Net Zero Teesside Project

Planning Inspectorate Reference: EN010103

The Net Zero Teesside Order

Document Reference: 9.21 Notification of Further Proposed Changes and Update on Remaining Optionality

Drawing Number	Rev
60559231-PE-DRG-054	0

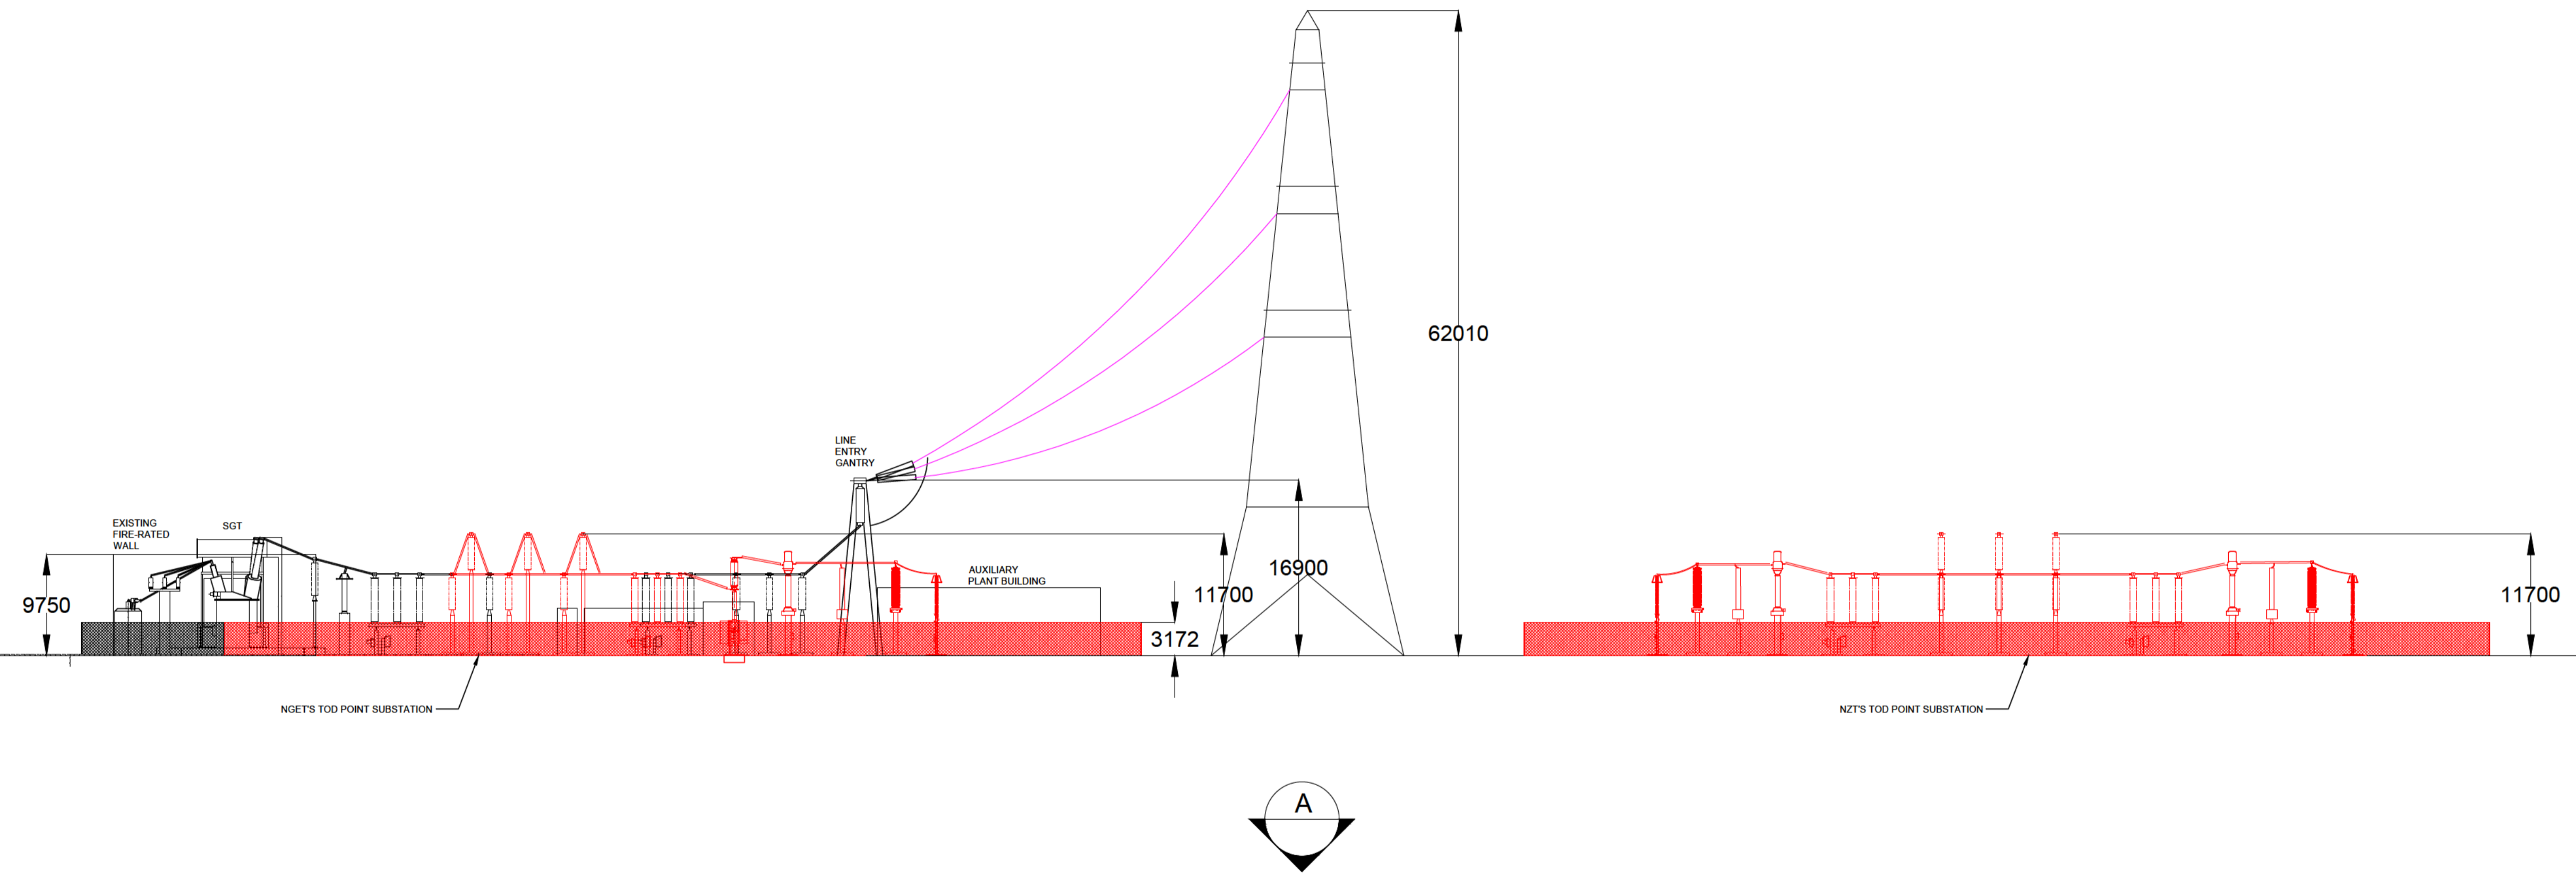
- 2.3.7 The electrical connection between Work No. 1A and Work No. 3B is subject to final selection of the cable routeing. As described in paragraph 4.3.67 of Chapter 4 Proposed Development of the ES [APP-086], there are two possible routeings for the Electrical Connection (1A and 1B). These two options only relate to routeing of the cables across part of the Teesworks site and crossing the Tees Valley railway line.

- 2.3.8 Through technical discussions with STDC, the Applicants have agreed in principle the Option 1A routeing of Work No. 3A within the Teesworks site. Option 1B continues to have an element of uncertainty and is reliant on installation of future infrastructure. Given the recent progress and supporting design development the Applicants propose to select Option 1A and remove Option 1B from the Order.

ALTERNATIVE ROUTE 2 - OPTION 2
Scale 1:25,000

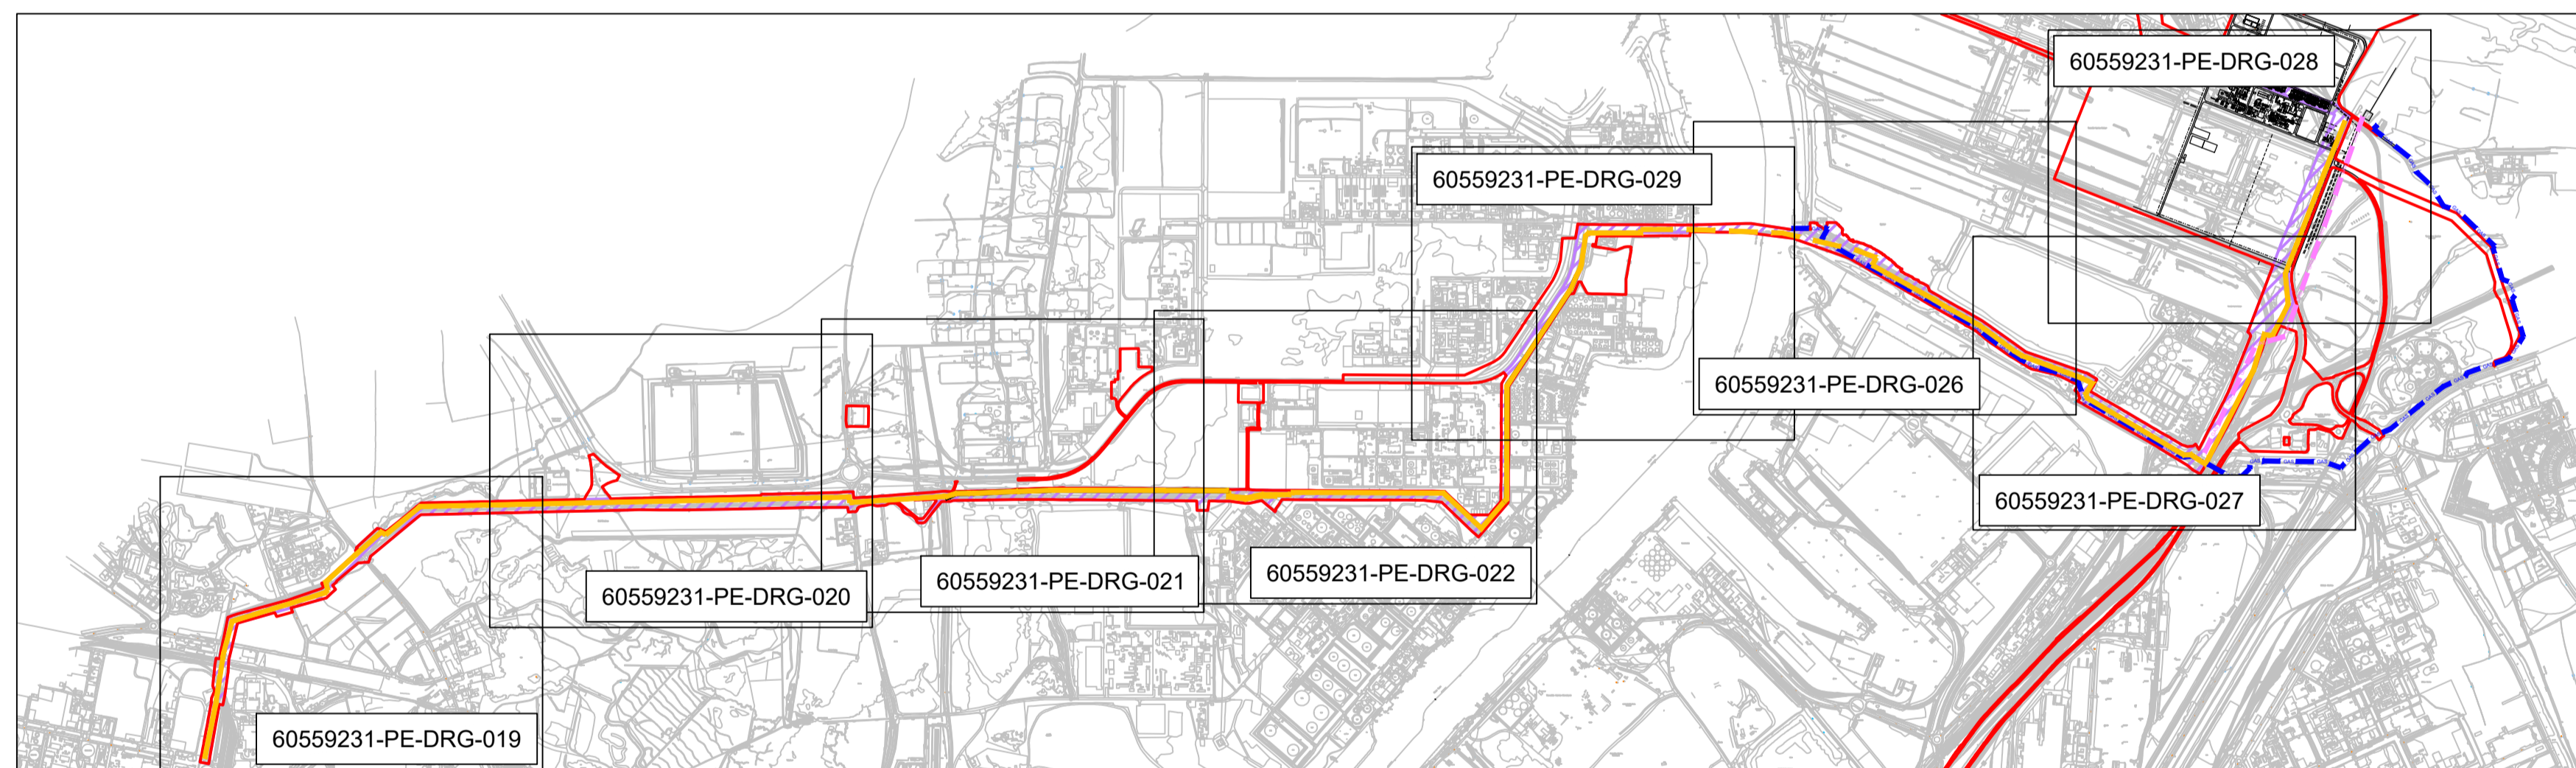
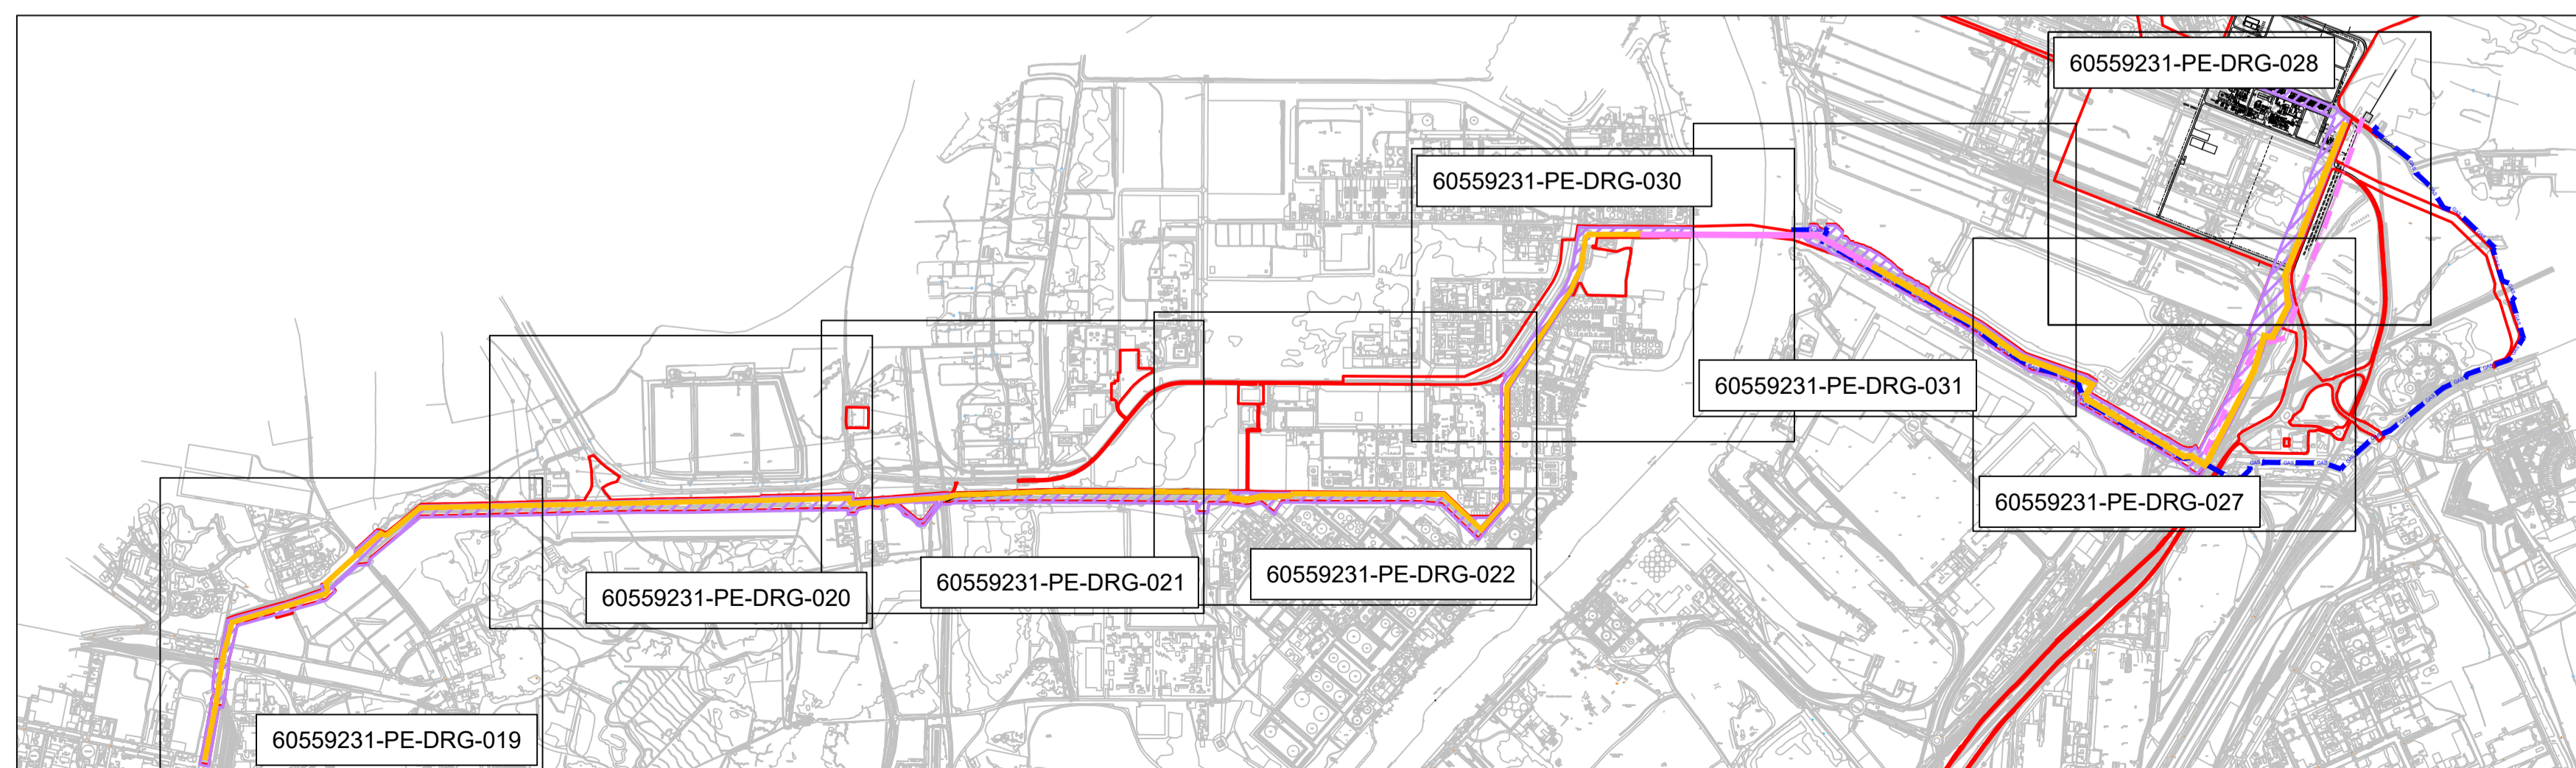
- 2.3.2 As part of the DCO Application, two options for the CO₂ Gathering Network crossing the River Tees are included:
- Option 2 (horizontal directional drilling) – installed using a horizontal directional drilled (HDD) bore drilled from a location on land on the north bank of Dabholm Gut to land near to Navigator Terminals on North Tees.

- 2.3.5 The Applicants propose to select Option 3 (Sembcorp Tunnel) and remove Option 2 (horizontal direction drilling) from the draft DCO.
- 2.3.6 The removal of Option 2 will have a beneficial impact of reducing the land requirements for the Proposed Development on both North and South Tees. These areas are shown on the indicative plans at Appendix 1.
